Application No: BN/18/20/PL
Site Address: Former Brooks Nursery Eastergate
Description of works: Variation of condition 15 imposed under EG/29/13/ relating to condition 15 - to change the foul drainage scheme from Sewage Treatment Plant to Pumping Station with associated drainage works.

Thank you for your internet representation made on 22nd June 2020 which has been recorded as an objection with the comments as follows:

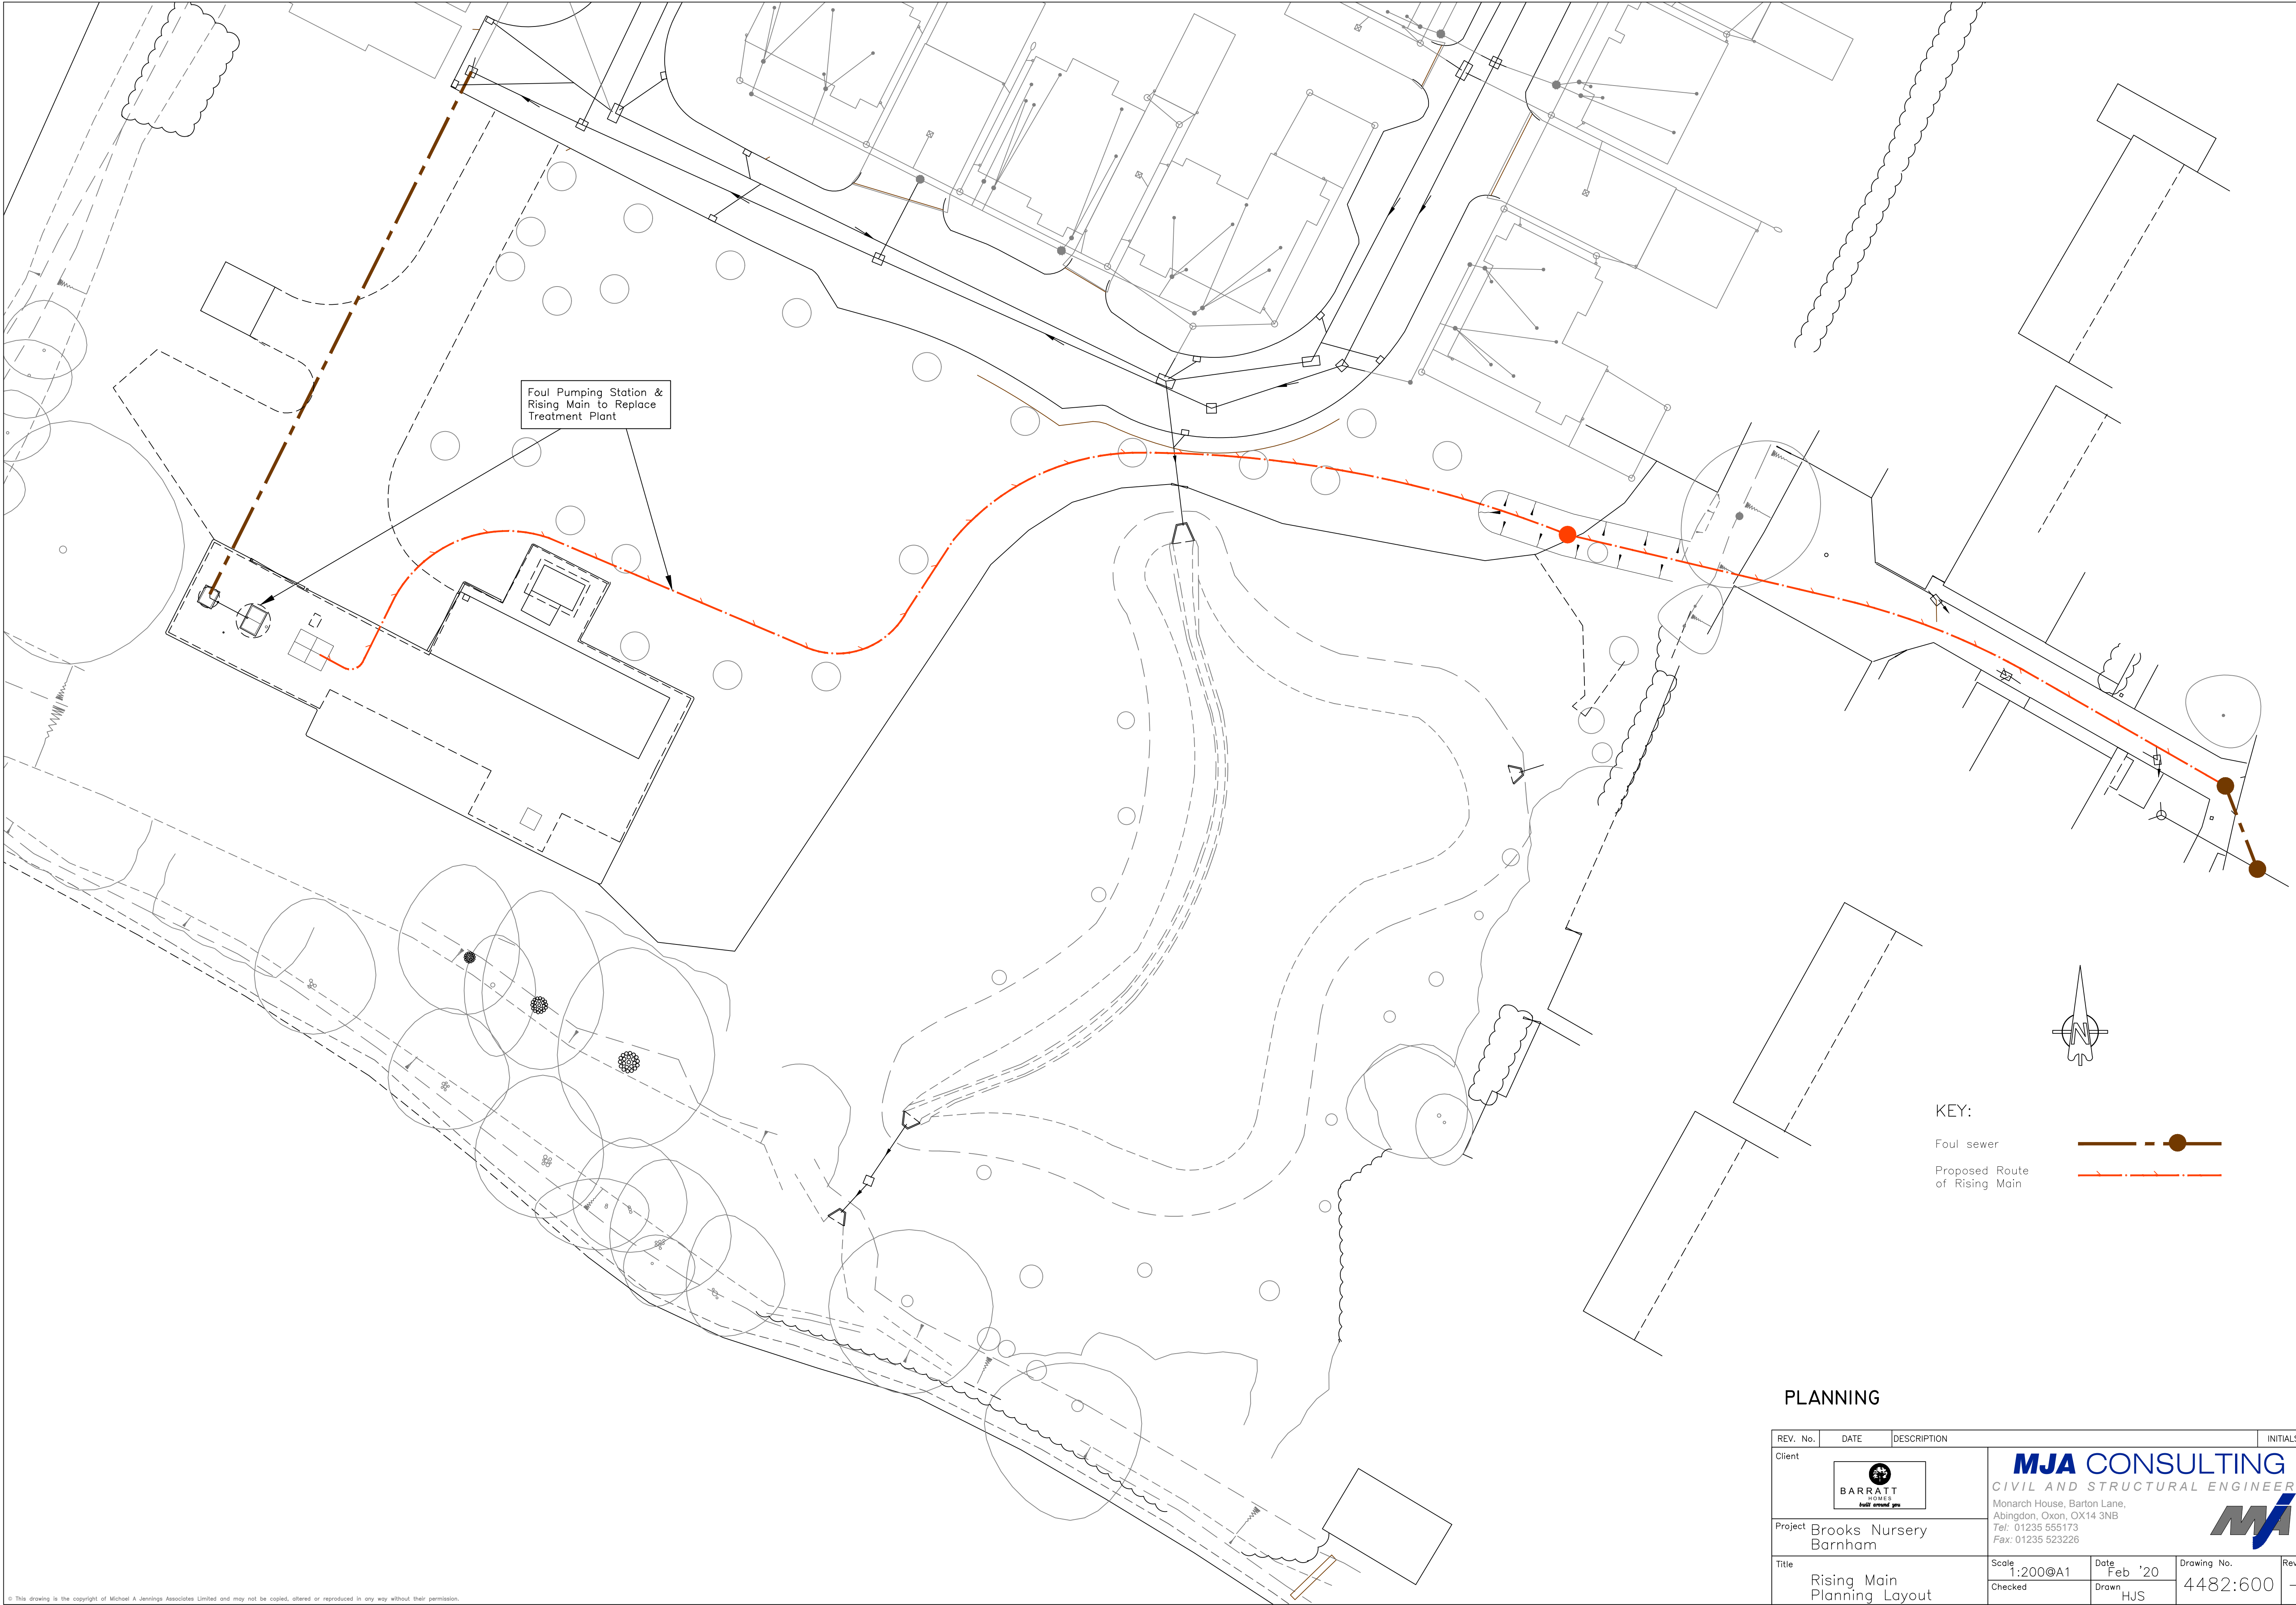
The connection of a new 8 inch pressurized sewage pipe from Upton Brooks to the existing 6 inch gravity pipes with non-return valves in the new 8 inch section should not be permitted. The risk of backing-up or sewage flooding from this configuration of sewers is too great to allow it to proceed.
